**KIRKLEES METROPOLITAN COUNCIL
INVESTMENT & REGENERATION SERVICE**

DELEGATED DECISION TO DETERMINE PLANNING APPLICATIONS

Reference No:	2024/62/93105/W
Site Address:	684, Bradford Road, Fixby, Huddersfield, HD2 2JY
Description:	Erection of two storey rear extension and first floor front extension with alterations to roof
Recommending Officer:	Molly Storer

DECISION – Full Conditional Permission

2129-24-003

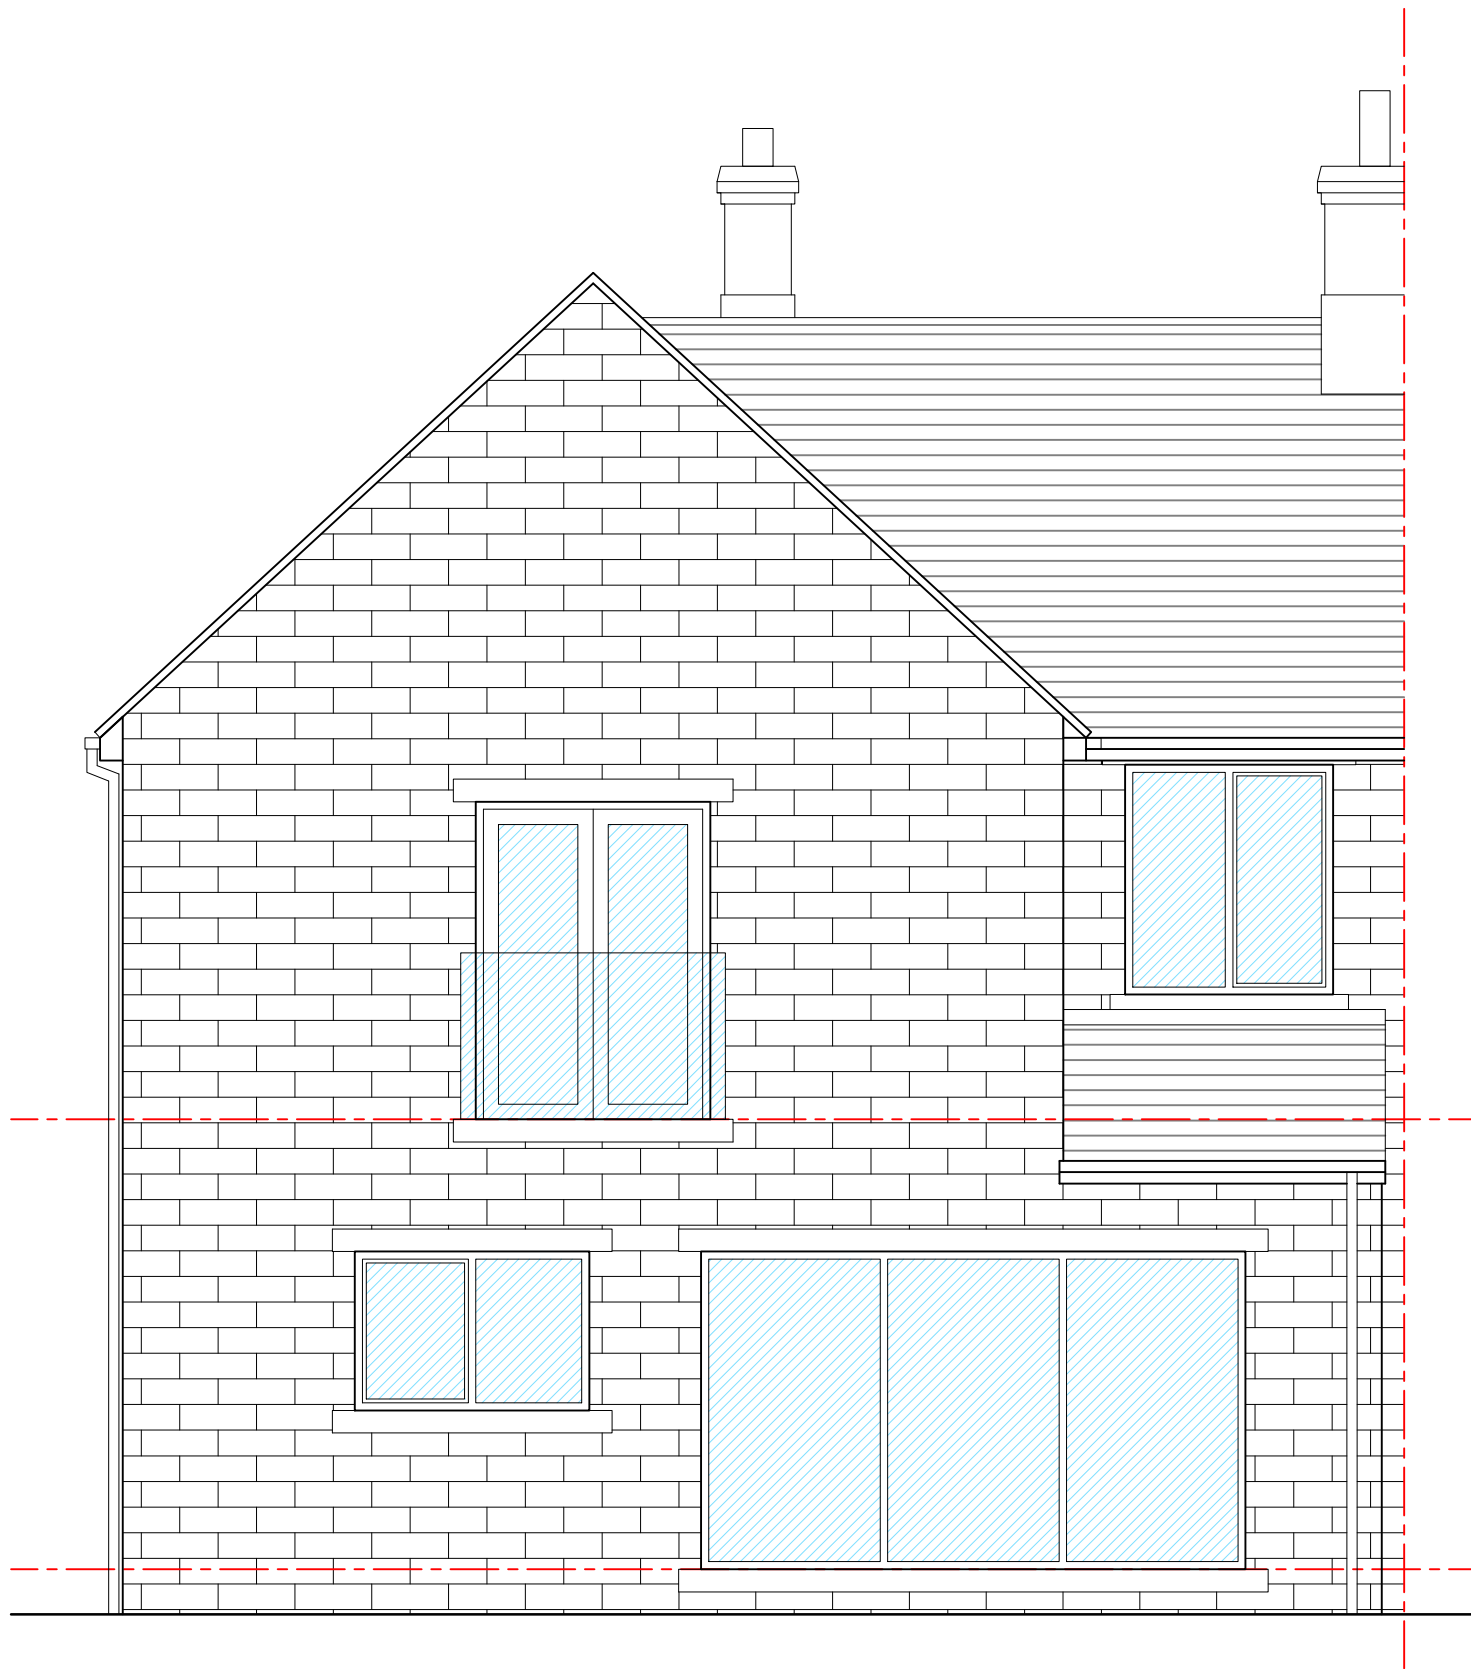
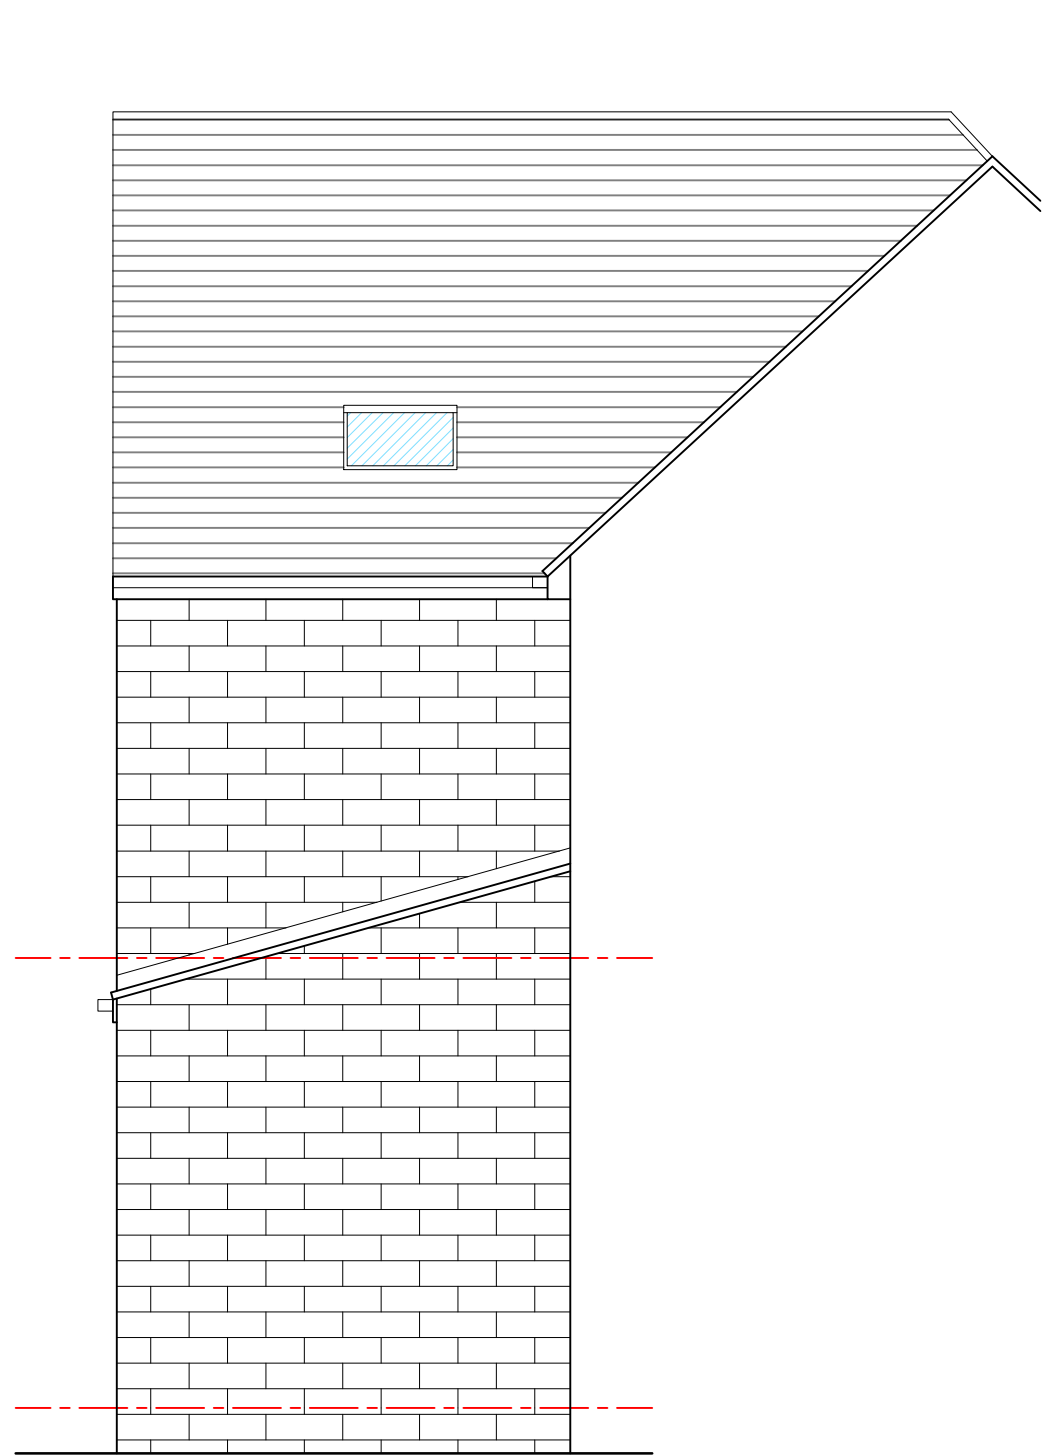
Amendments were sought as the original plans showed the gable roof height extending above the existing roof ridge. The agent amended plans to show the proposed ridge in line with the existing. In order to maintain the internal space required this meant lowering the eaves height by 0.5m on one side.

2129-24-003

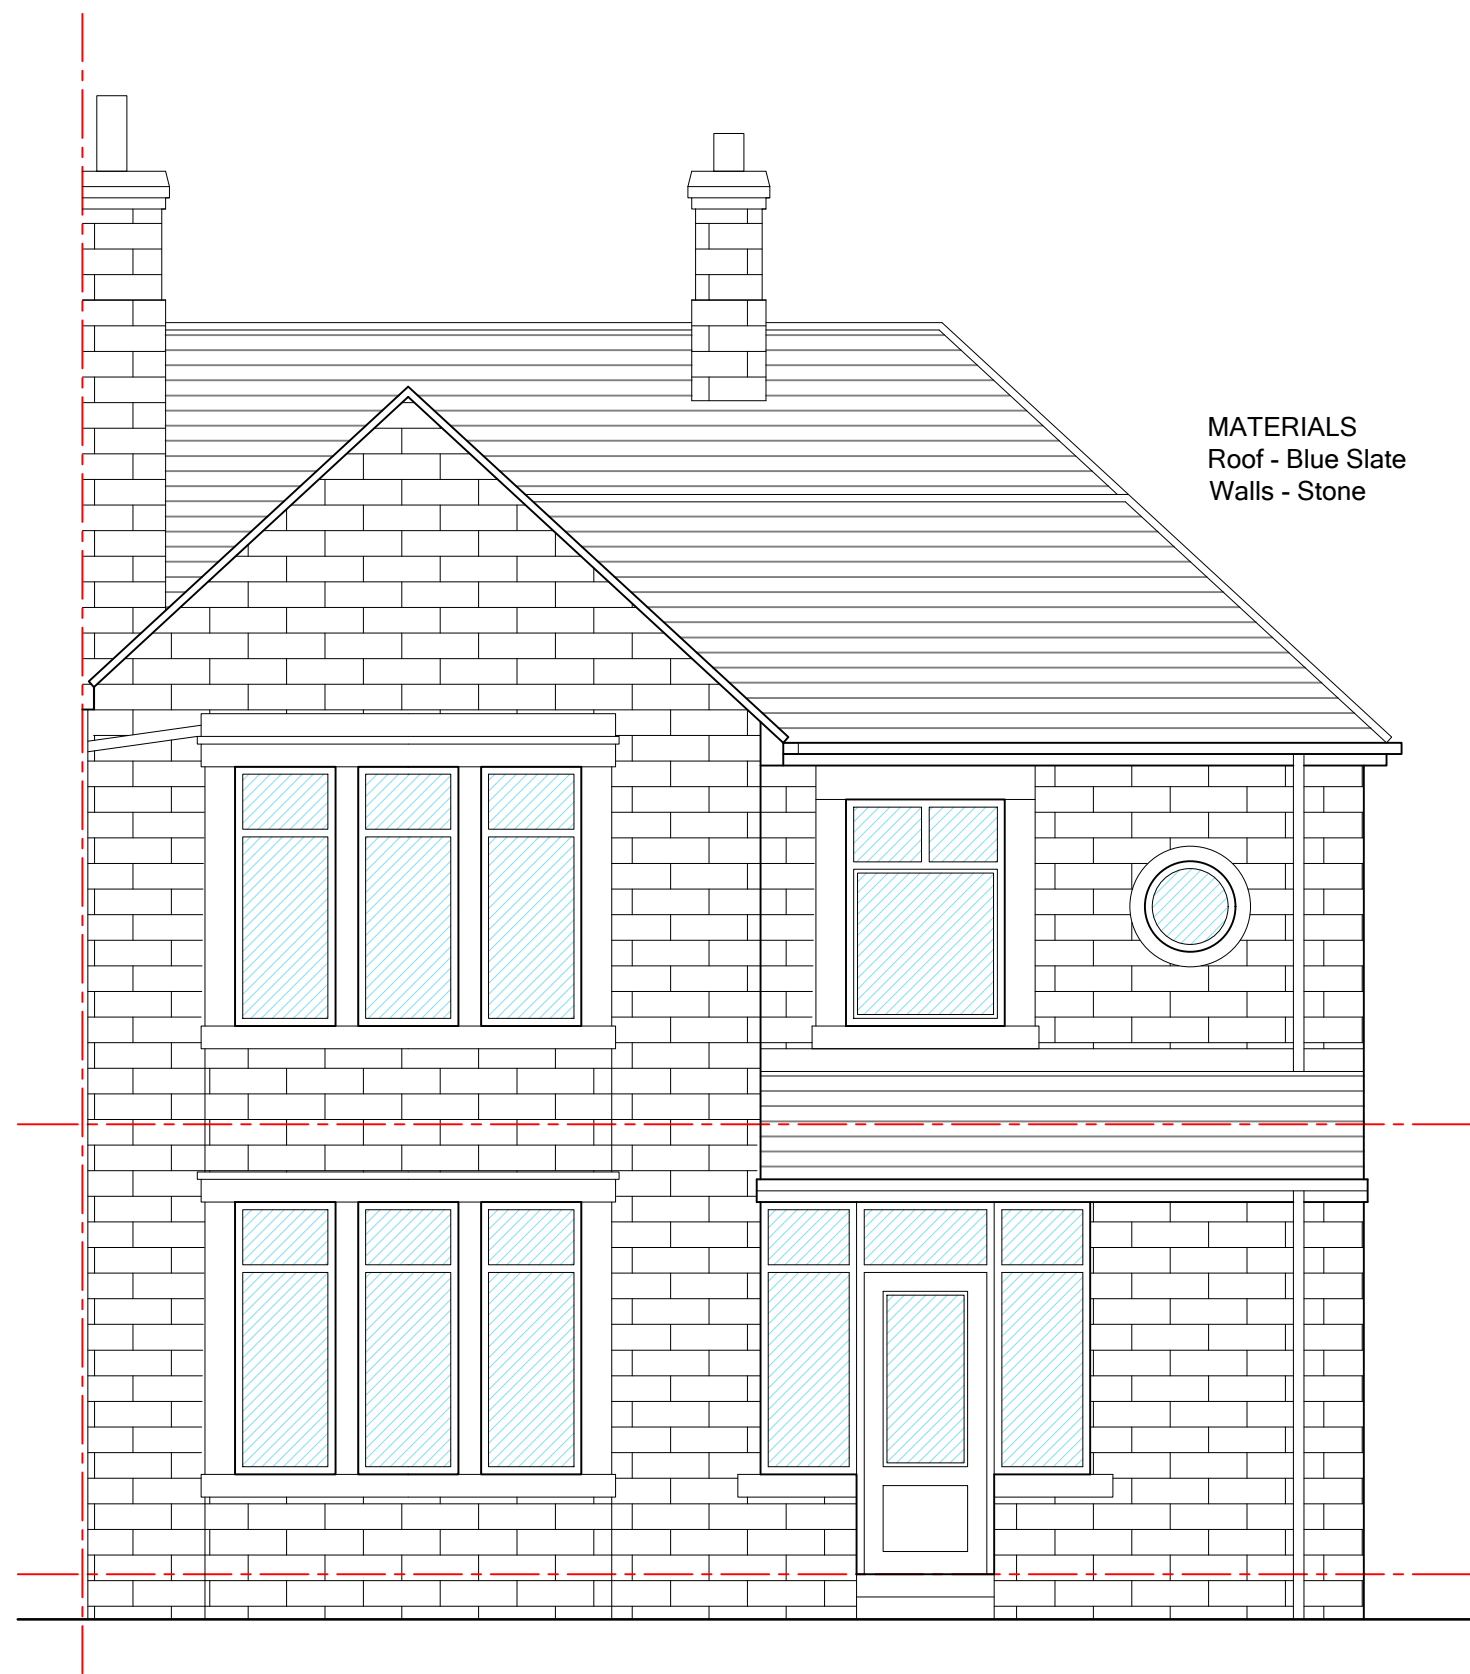
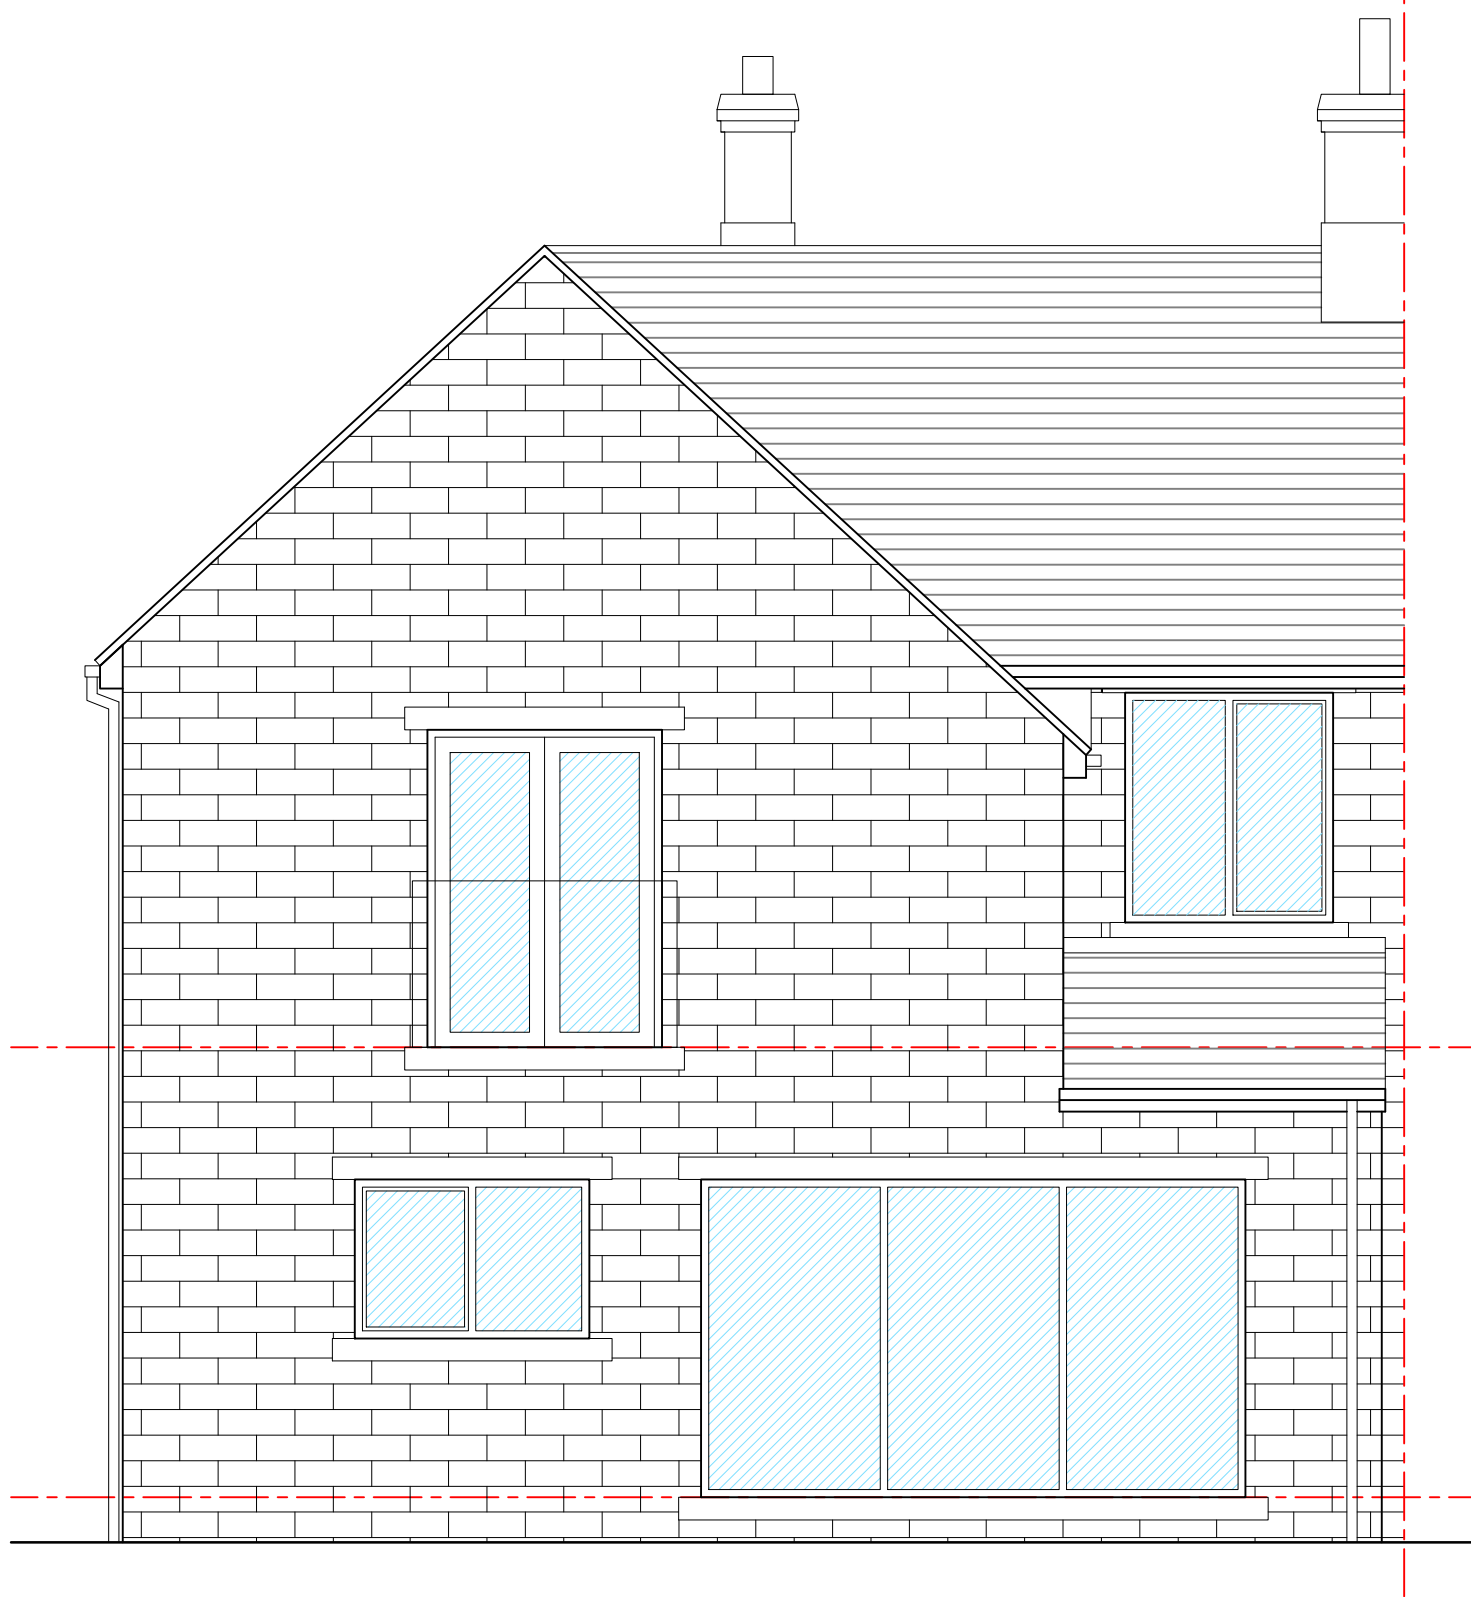
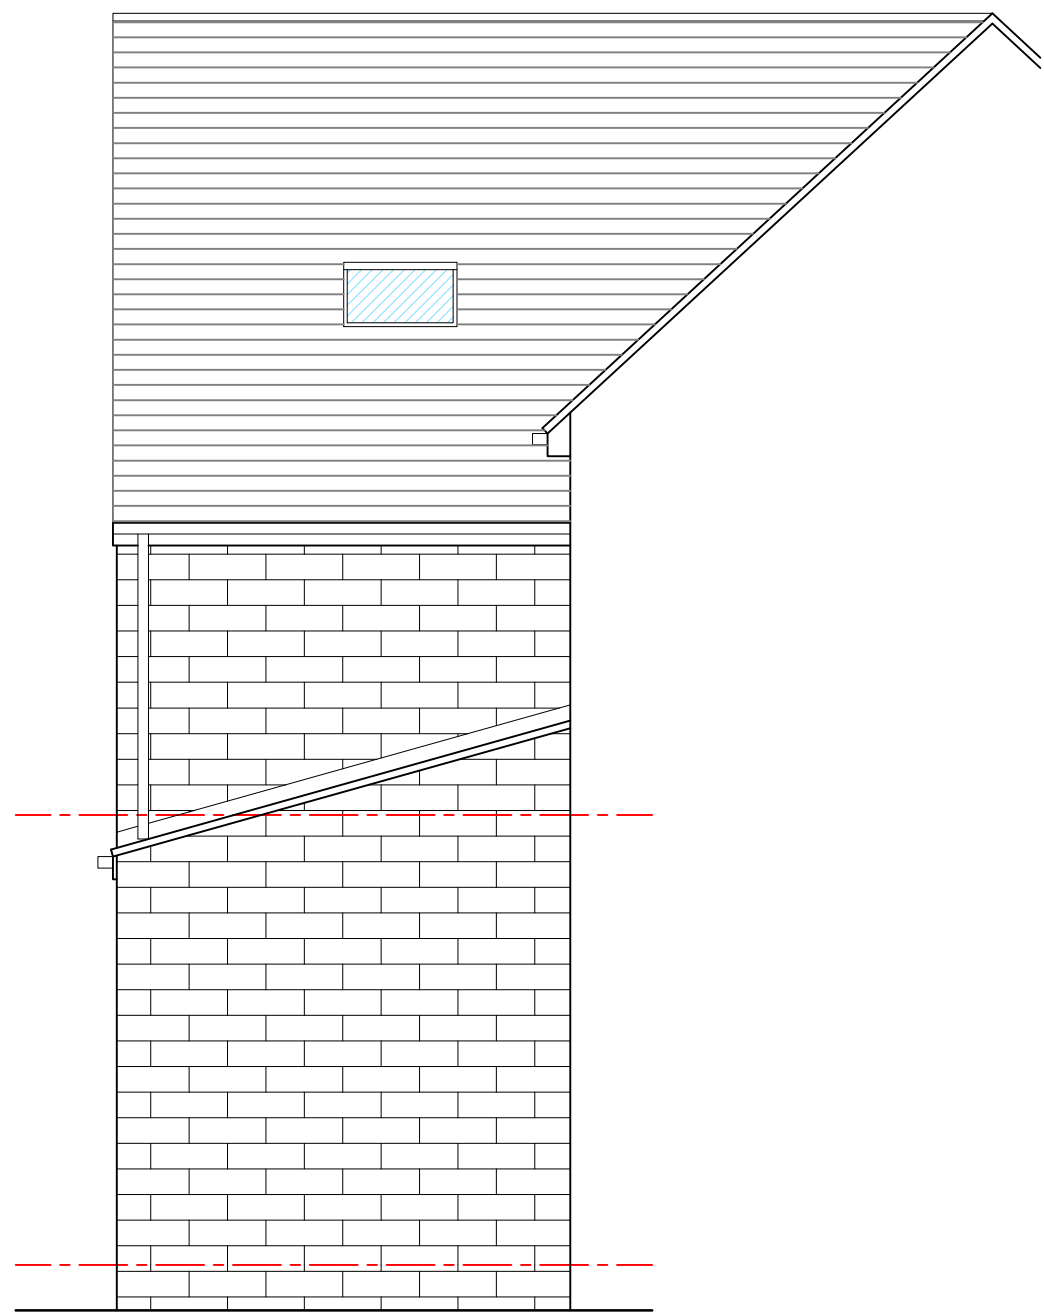
The rear element will extend 3m beyond the rear wall and will replace the existing (original) reward projection. This will be comprised of a single storey element and a two storey element. The two storey element will have a width of 6.22m, a height to the eaves of 5.75m on one side and 5.25 on the other (this was a change to the original design to accommodate for the lowering of the ridge high whilst retaining the required space internally) and an overall height of 8.8m with a gable roof. The single storey element will have a width of 2.1m, height to the eaves of 2.9m and an overall height of 3.9m with a lean to roof.

Pursuant to article 35 (2) of the Town and Country Planning (Development Management Procedure) Order 2015 and guidance in the National Planning Policy Framework, the Local Authority have, where possible, made a pre-application advice service available, complied with the Kirklees Development Management Charter 2015 and otherwise actively engaged with the applicant in dealing with the application. Amendments were sought as original plans showed the gable roof height extending above the existing roof ridge. The agent amended plans to show the proposed ridge in line with the existing. In order to maintain the internal space required this meant lowering the heaves height by 0.5m on one side. These plans were considered acceptable.
